KITTITAS COUNTY

MEMORANDUM

TO: All Staff
FROM: Public Works Plan Review Team
DATE: April 4, 2025
SUBJECT: LPF-25-00002 Sasse

SASSE RIDGE PLAT

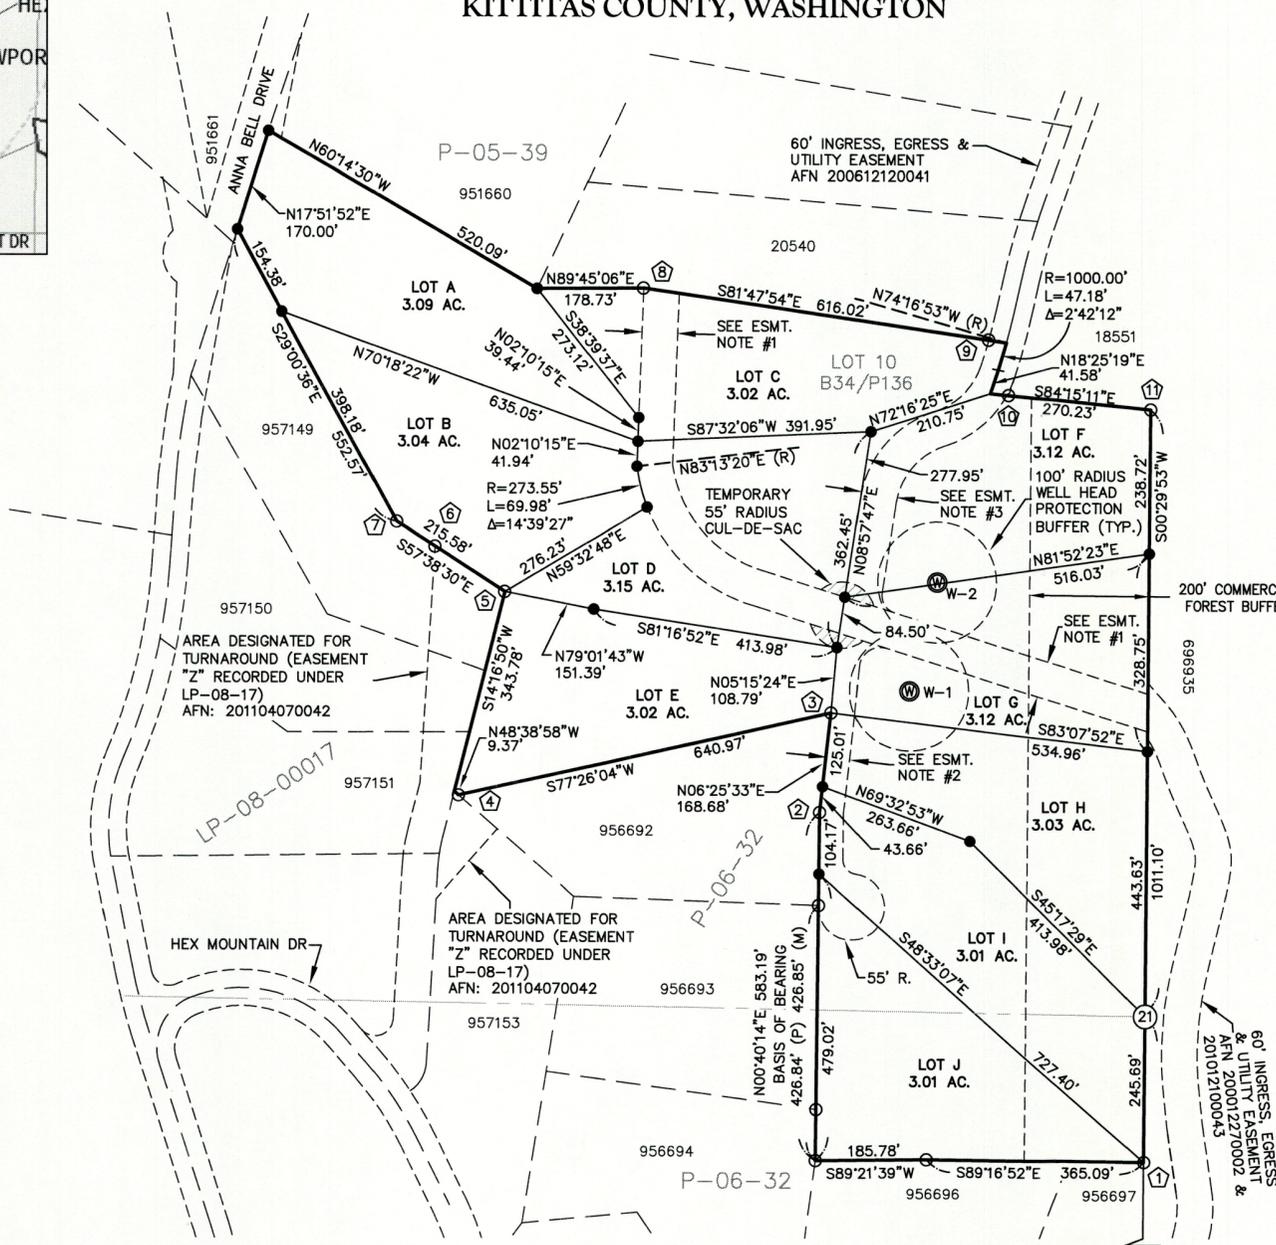
| SURVEY | <ol style="list-style-type: none">1. Easements S, T and U shall be denoted as to if they are existing, herein created, or created via separate document. If they are existing, include reference to the document recording number. If they are herein dedicated, they need to be retraceable, either by including metes and bounds, or including language “centered about existing road” (or similar).2. The areas denoted as “Temporary 55’ Radius Cul De Sac” needs to address whether it is existing, herein dedicated, or to be created via separate document. If existing, include reference to the recording number, if herein dedicated, it needs sufficient data for mathematical retracement. Please address the temporary nature, via a note detailing what action would terminate the easement.3. Please label roads with R/W width, ownership and surfacing (EX: Anna Bell Drive-60’ Private R/W-Paved) |
